Subject: Former Grove URC Chapel Oxford Road, Gomersal, Cleckheaton, BD19 4JY Application 2023/90073
Date: 21 February 2023 09:54:55

Thankyou for your consultation, received via the Joint Committee casework hub.

GROUND FLOOR
 1 : 100

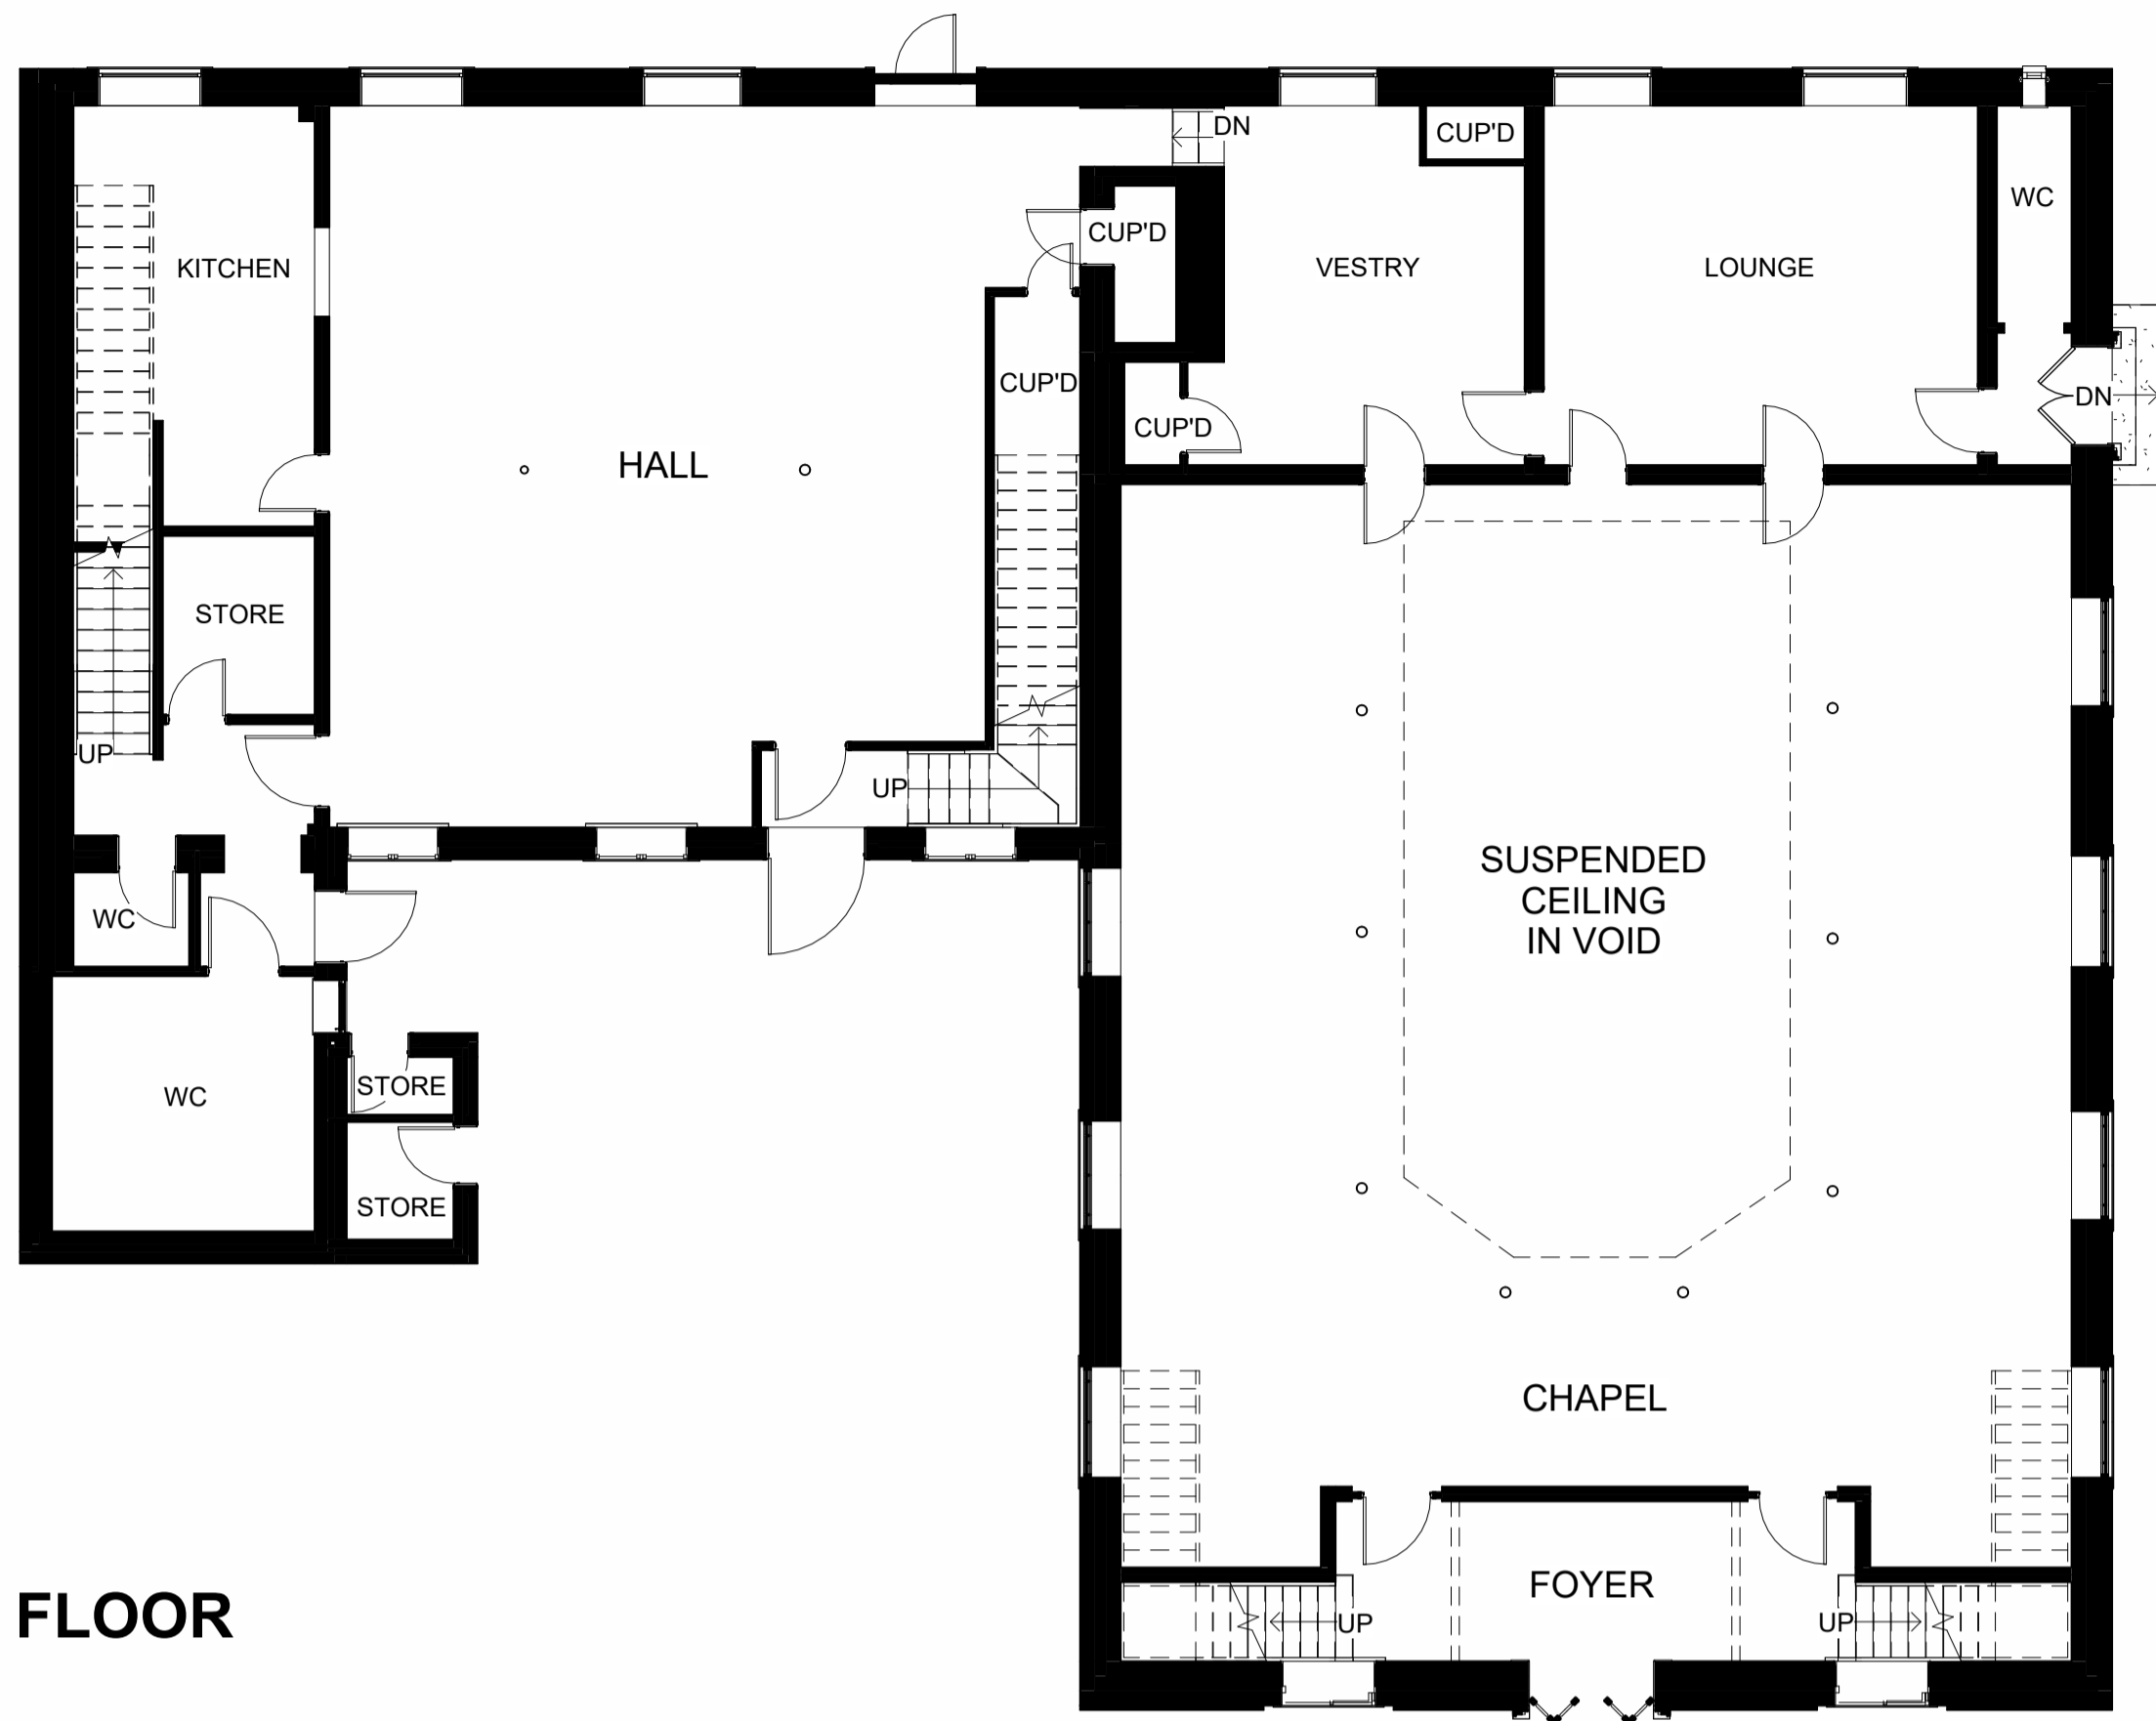
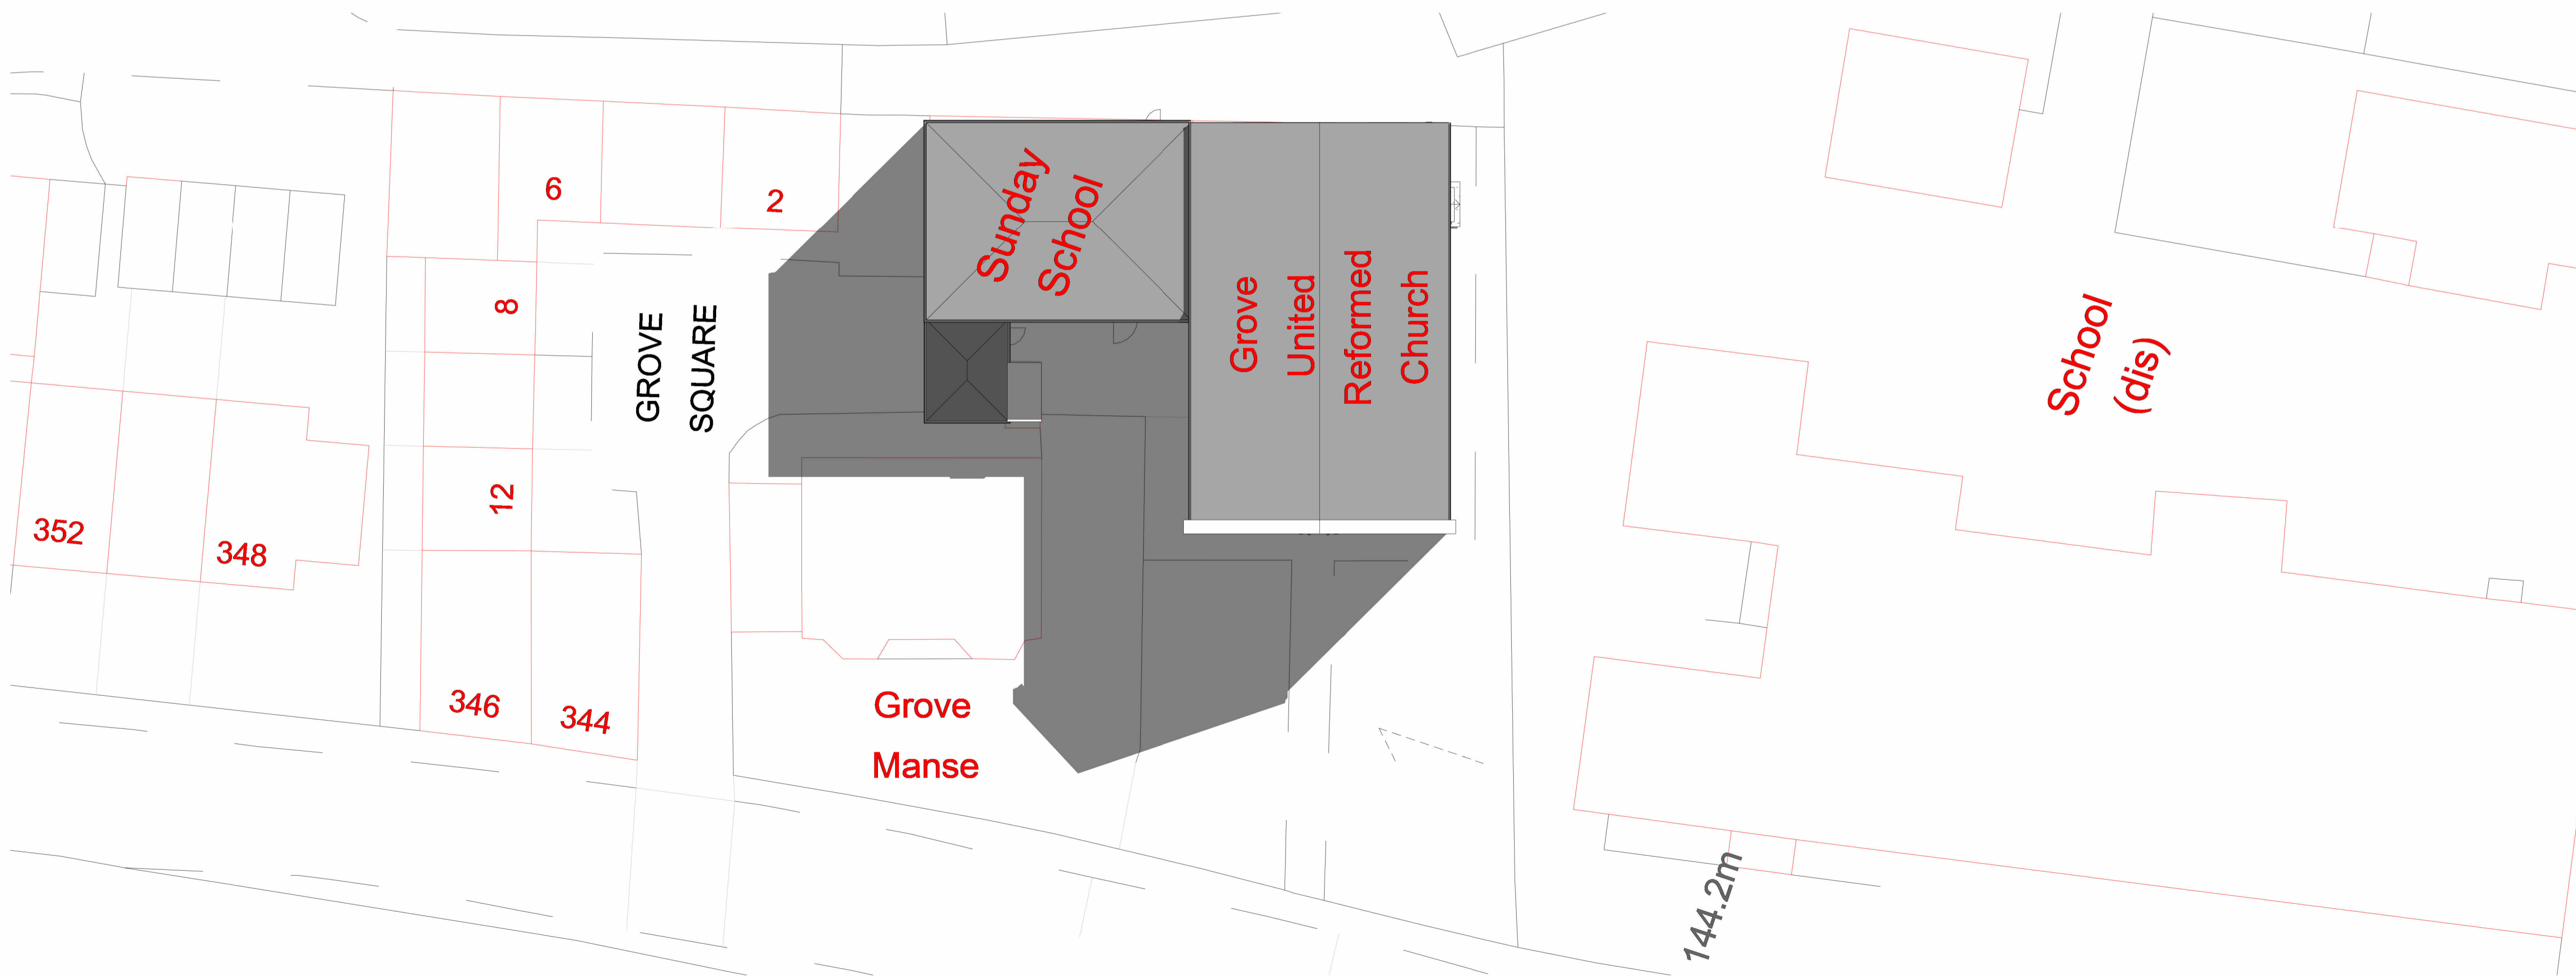
We must express considerable disappointment at the intensity of the conversion. The insertion of as many as 10 residential units effectively breaks up the historic interior.

At 4.16 the Heritage Statement lists some possible ameliorations but the scale of the drawings is such that it is impossible to test how many, if any, have been taken up.

1. It needs to be established first that a use is not possible which works with the character of the interior as a purpose-built auditorium (with the removal of the inserted floor). How wide has been the marketing ?
2. Secondly why is it not possible to limit the intense conversion to the Sunday School, which is the lesser and more altered of the two listed buildings ?
3. Why must there be so many units in the chapel interior ? The lobby and the gallery stairs are retained but very little else. Is it not possible to provide more substantial but fewer units in the chapel thus reducing the need for so many subdivisions ?
